Our ref: Berrima Cement Facility (DA401-11-2002-i-Mod-14)

Subject: Response to Submissions – Department of Planning and Environment Issues

I refer to the Department of Planning and Environment's (Department) request for a response to issues raised in government advice dated 28 April 2022 for the proposed modification to the Boral Cement Facility, Berrima (DA401-11-2002-i-Mod-14).

ATTACHMENT 1 – Department's Issues

Figure 13 Truck Routes Across Site Current Operations (As Modelled)

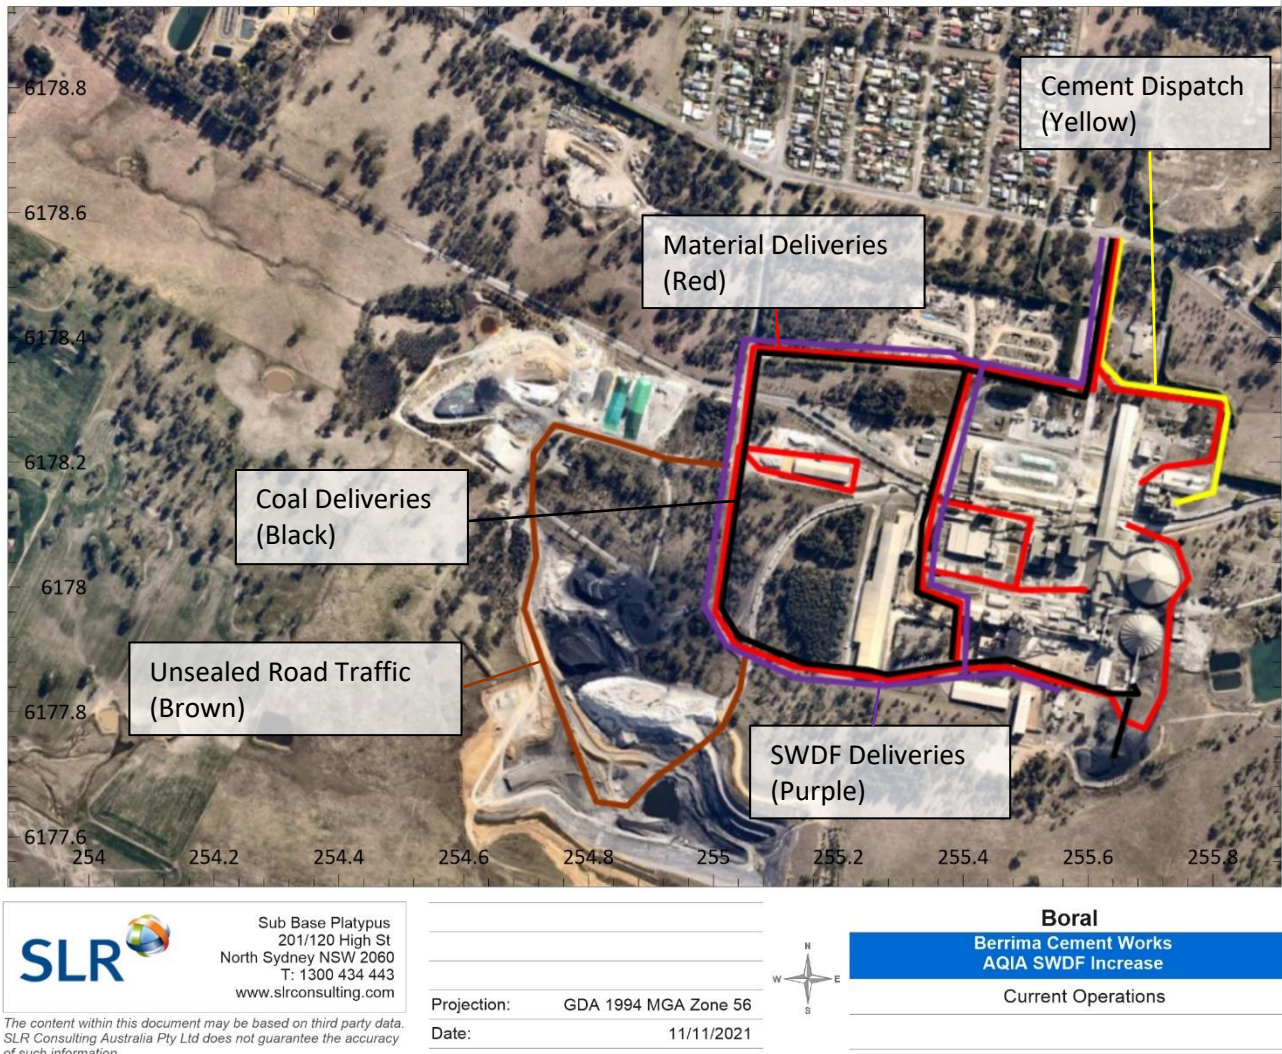
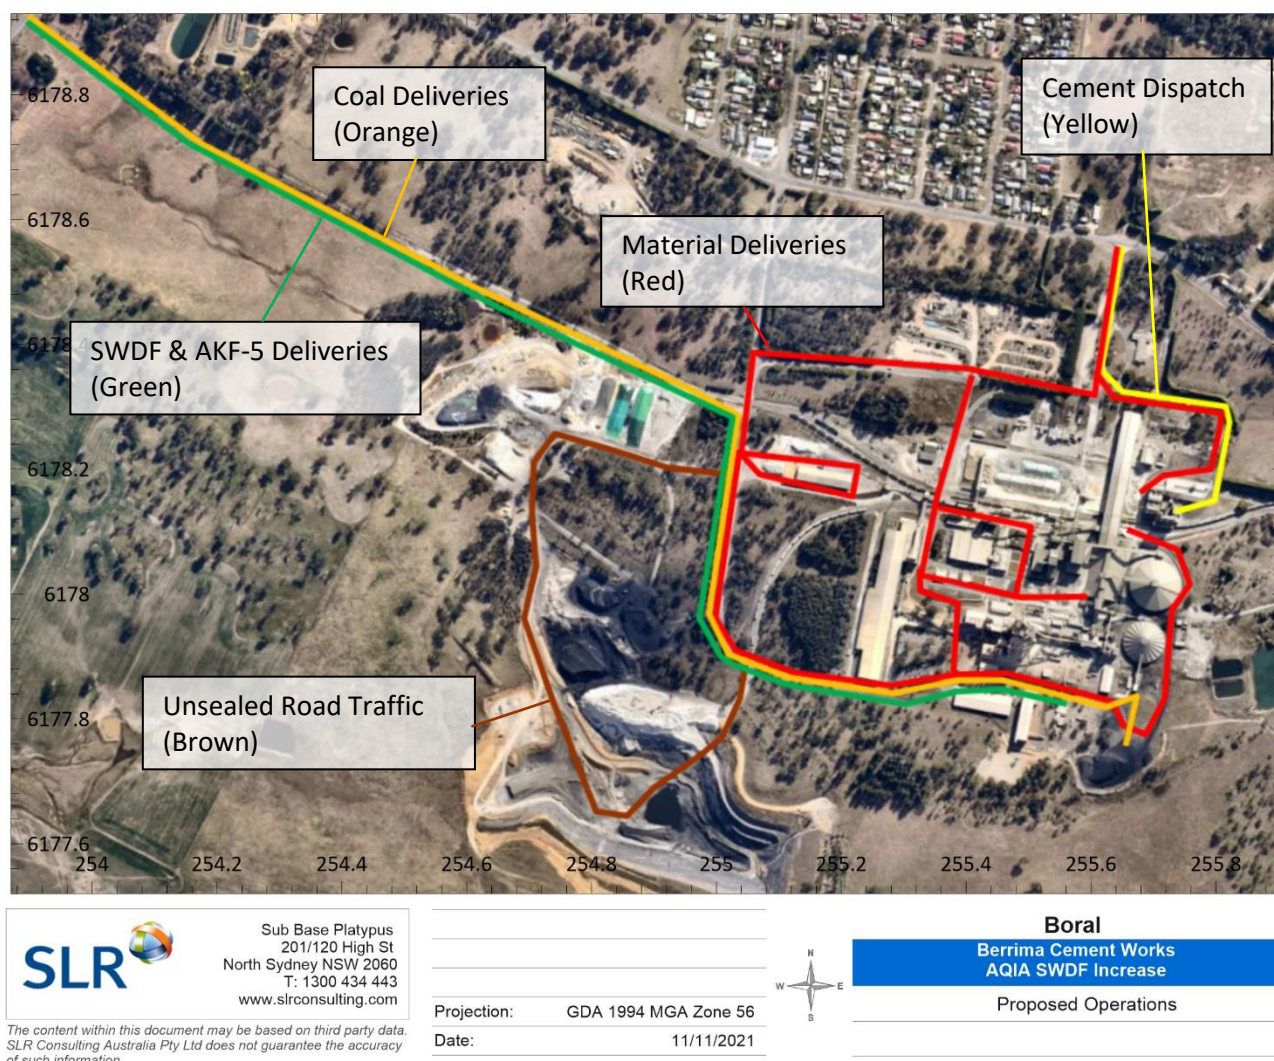
Table 2 of the AQIA provides a summary of the proposed truck movements associated with the modification upon which the assessment of fugitive dust emissions has been carried out. This has not included the additional truck movements associated with the receipt of 150,000tpa of woodchips.

Recommendation: The AQIA should be revised to account for the fugitive emissions generated by the additional truck movements from the delivery of up to 150,000tpa of woodchips to the site.

REFERENCE DRAWINGS	
DRAWING	DESCRIPTION
BER-G-LAY-601-09-01	SWDF EXPANSION ELEVATIONS

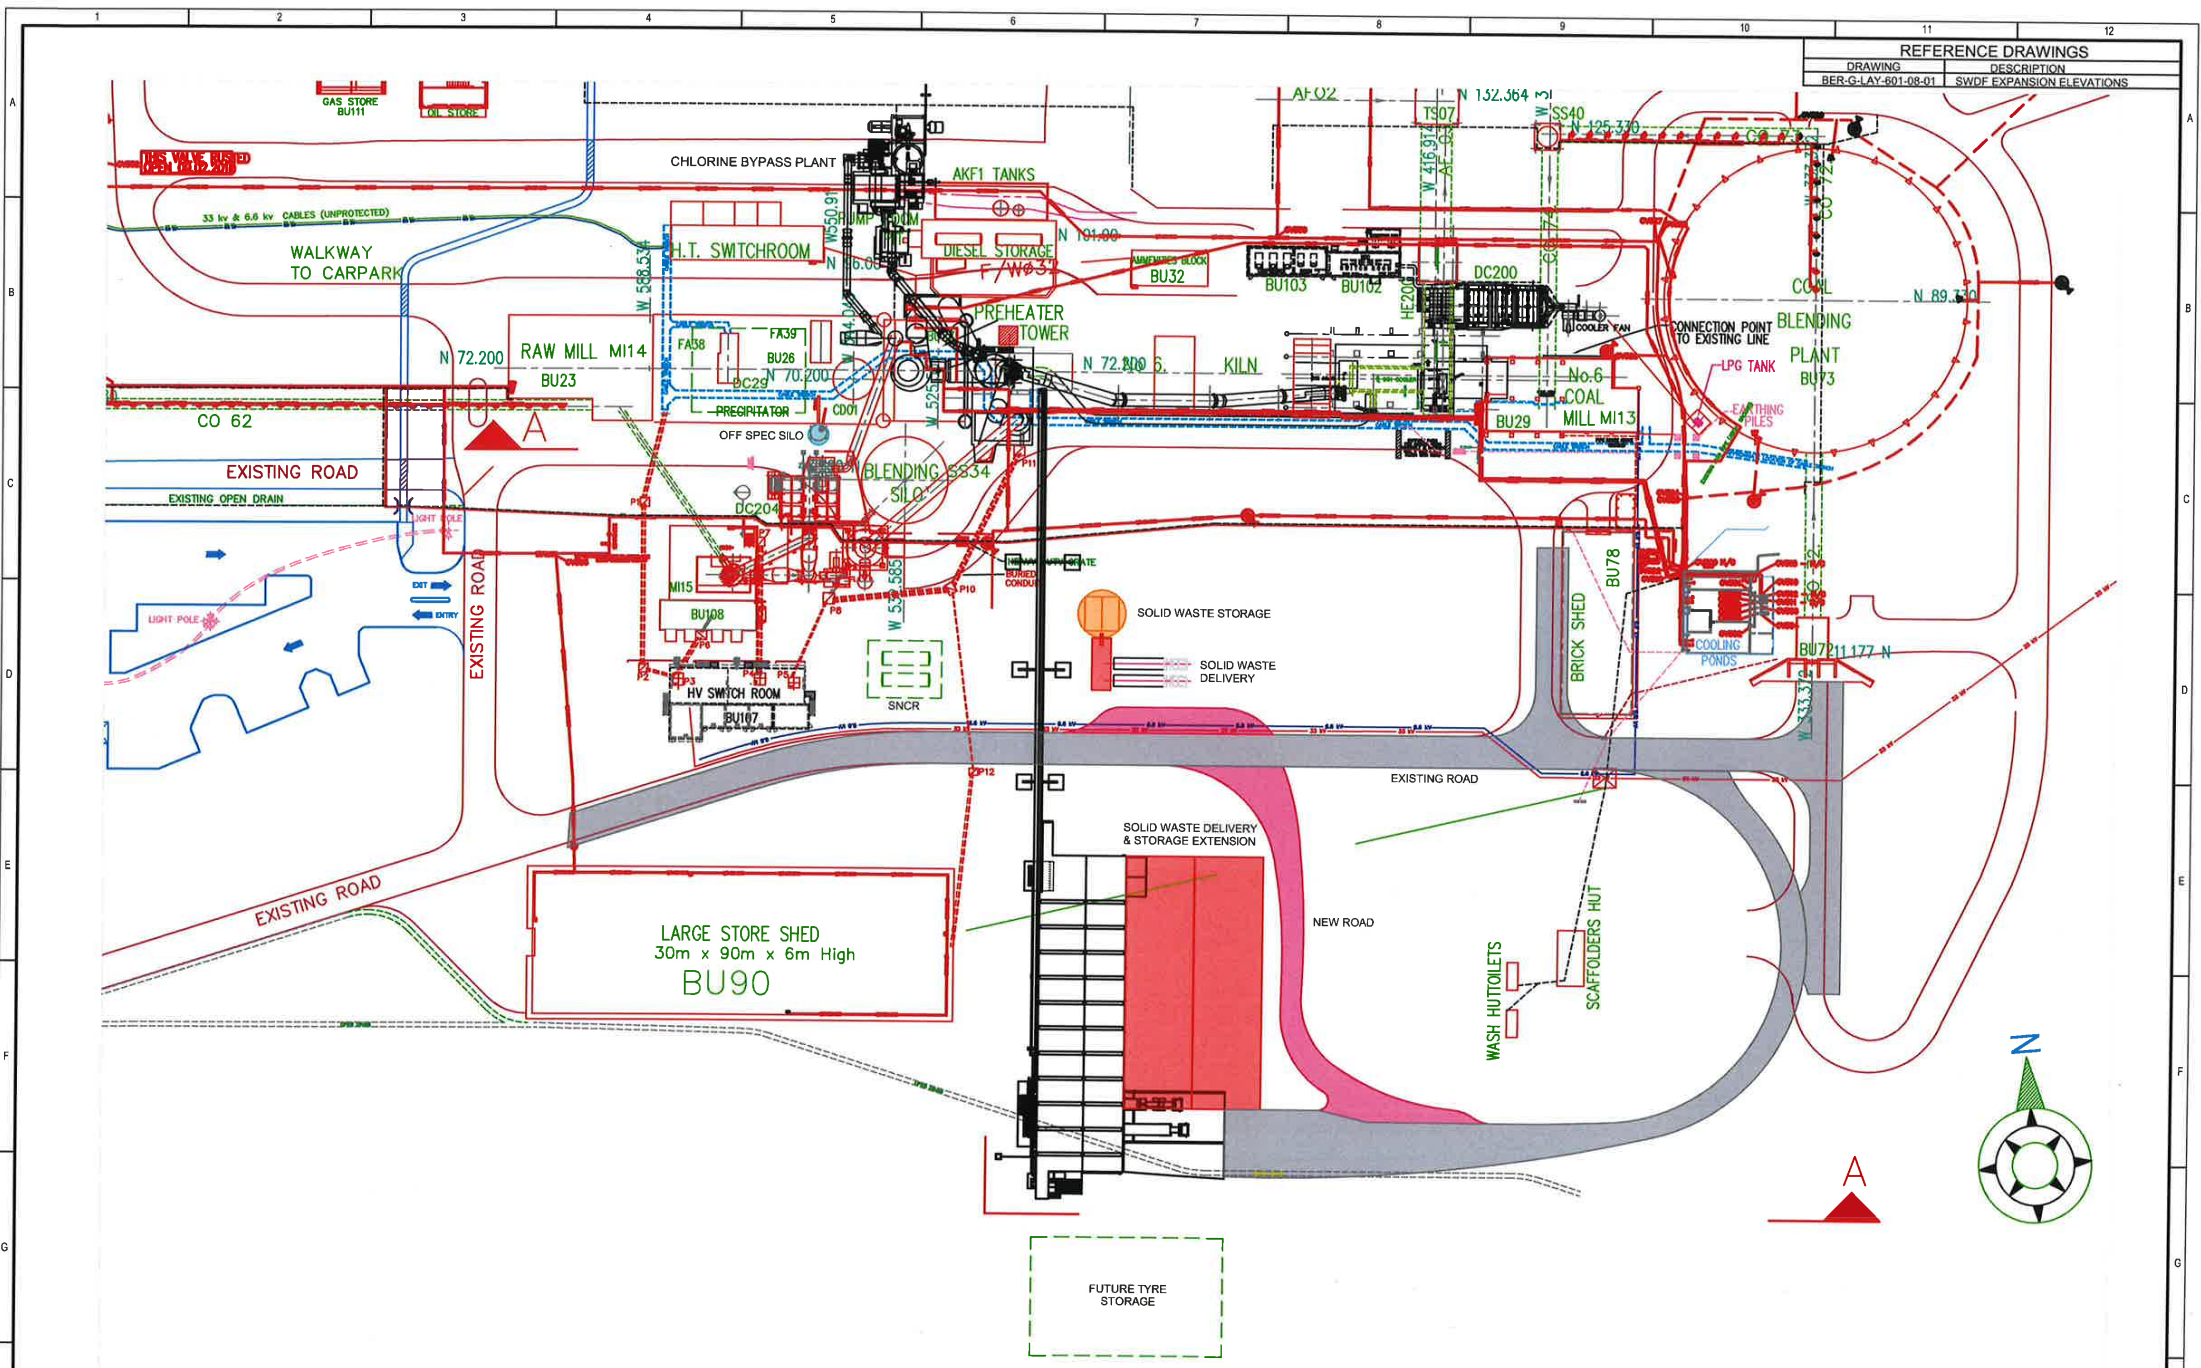
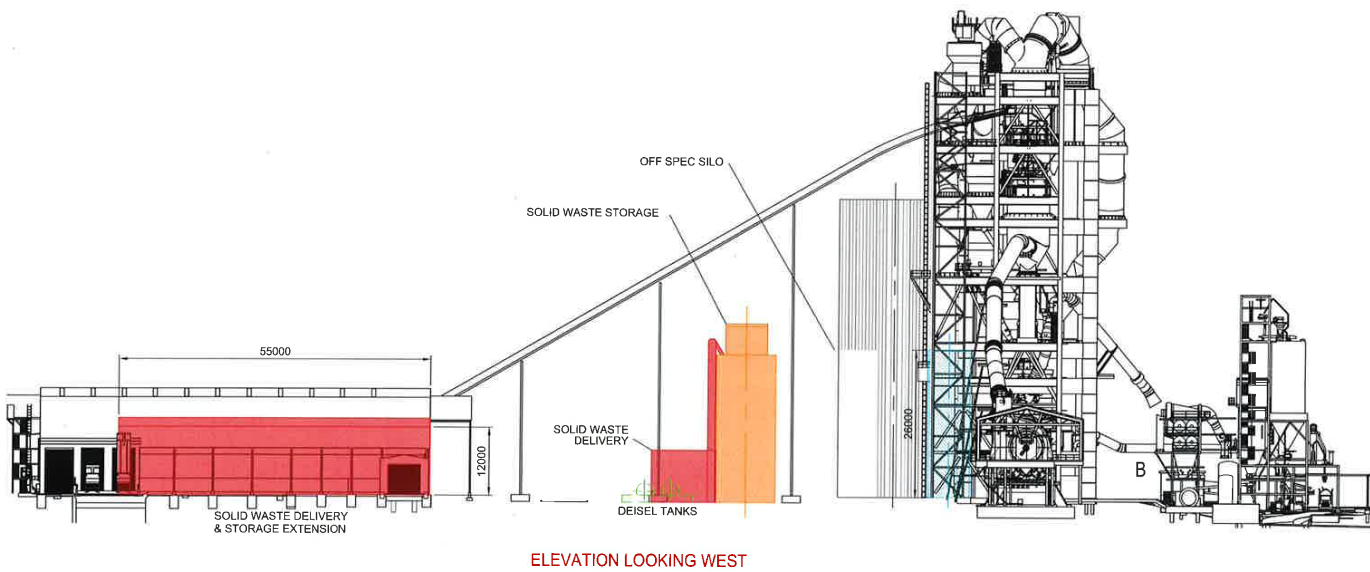
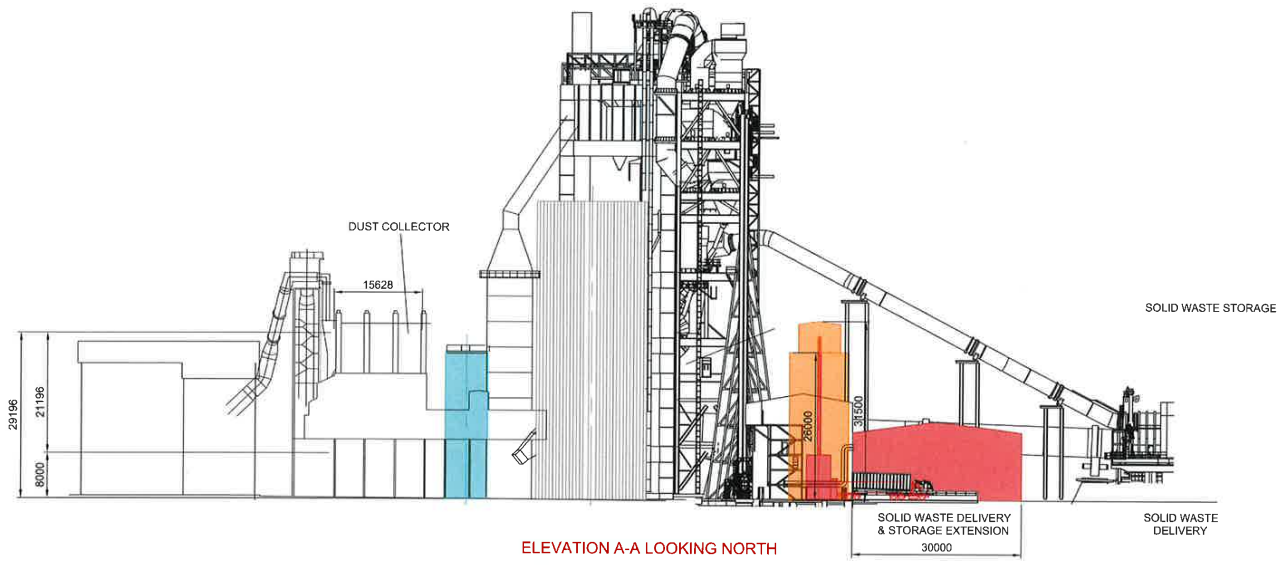
The design drawings in Appendix A of the SEE show two areas shaded red and one new building shaded orange, labelled as 'solid waste storage' and/or 'solid waste delivery'. The dimensions of the larger of these buildings is marked as 30x55m, which does not align with the dimensions in Table 8 of the SEE. The dimensions of shed 2 as outlined in Table 8 also do not appear to be correct (0.7m wide x 1.63m long x 0.5m high).

Details of the proposed construction materials and methodology for the sheds has not been provided.

Recommendation: Please provide further details to confirm the use, scale, construction materials, design (e.g. will they be pre-fabricated) and activities to be carried out in all new buildings. A key should also be provided on the design drawings to clarify the use of red and orange shading.

Figure 5: The Proposed New Haul Road

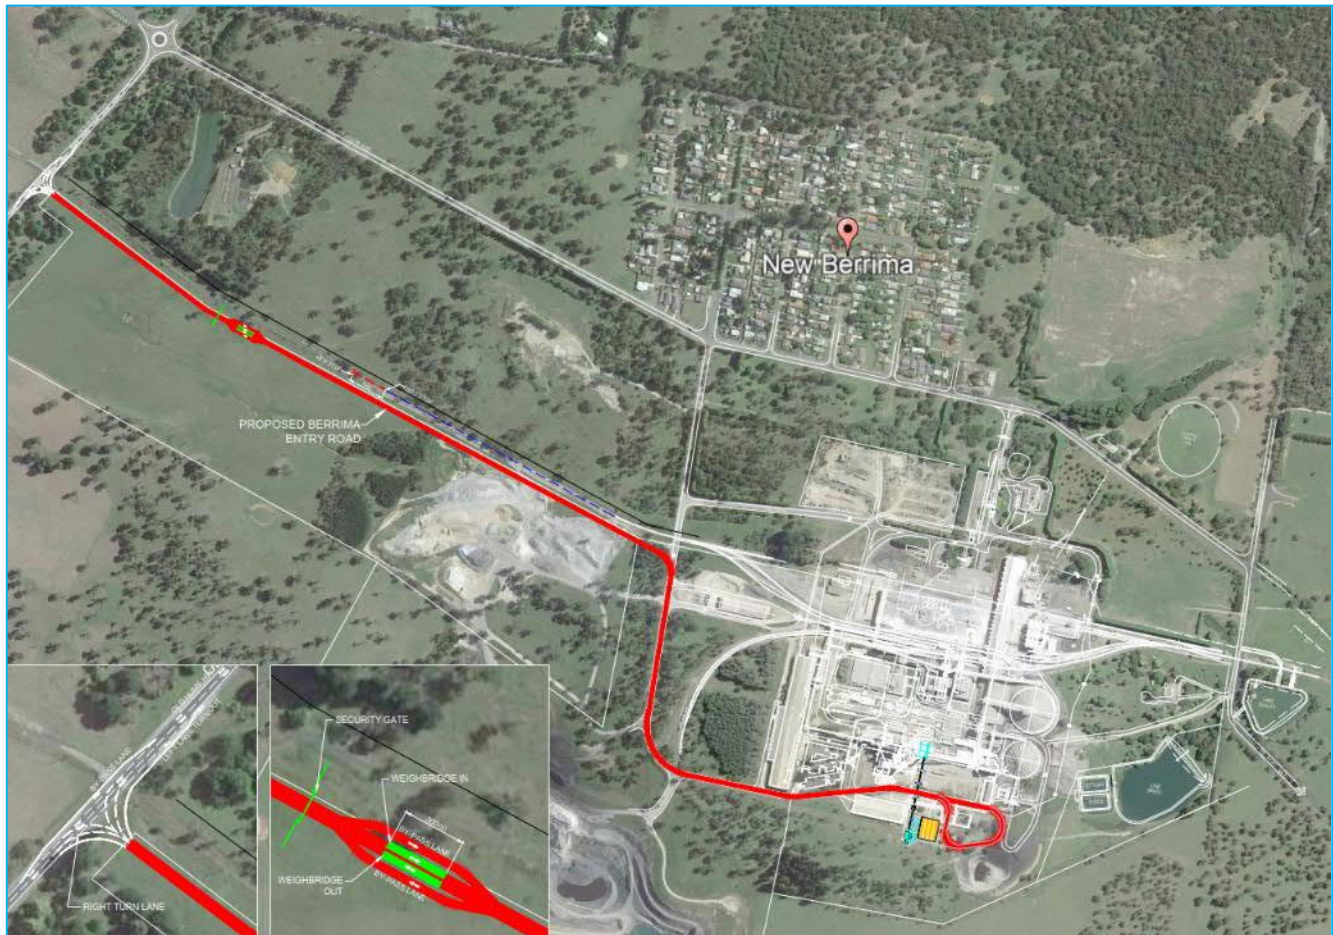
The supporting impact assessments identify a road and powerline easement and previous railway works that have been undertaken in the vicinity of the proposed new haul road. The biodiversity assessment also notes the alignment has been designed to avoid areas of native vegetation. The plans do not provide sufficient detail to demonstrate the road alignment in relation to the existing easements, previous railway works and area of native vegetation.

Recommendation: Please provide a plan of the proposed haul road that clearly shows all existing constraints along and adjacent to the proposed new site access road alignment, including easements, areas of native vegetation and watercourses etc. The plan should include the location and details of any culverts.

Section 4.2.6 of the SEE states that no works are proposed within 40 metres (m) of a watercourse. However, Figure 2 of the SEE shows that the proposed new access road would cross over a tributary of Oldbury Creek.

Recommendation: Further consideration of any requirements under the *Water Management Act 2000* is required.

Appendix F of the TIA provides concept civil drawings of the proposed new site access road intersection with the Old Hume Highway. The drawing package does not include any design drawings of the proposed new haul road between the intersection and site fuel storage facilities.

Recommendation: Concept design details of the full length of the access road should be provided, noting in particular how the watercourse crossing (tributary of Oldbury Creek) will be designed.
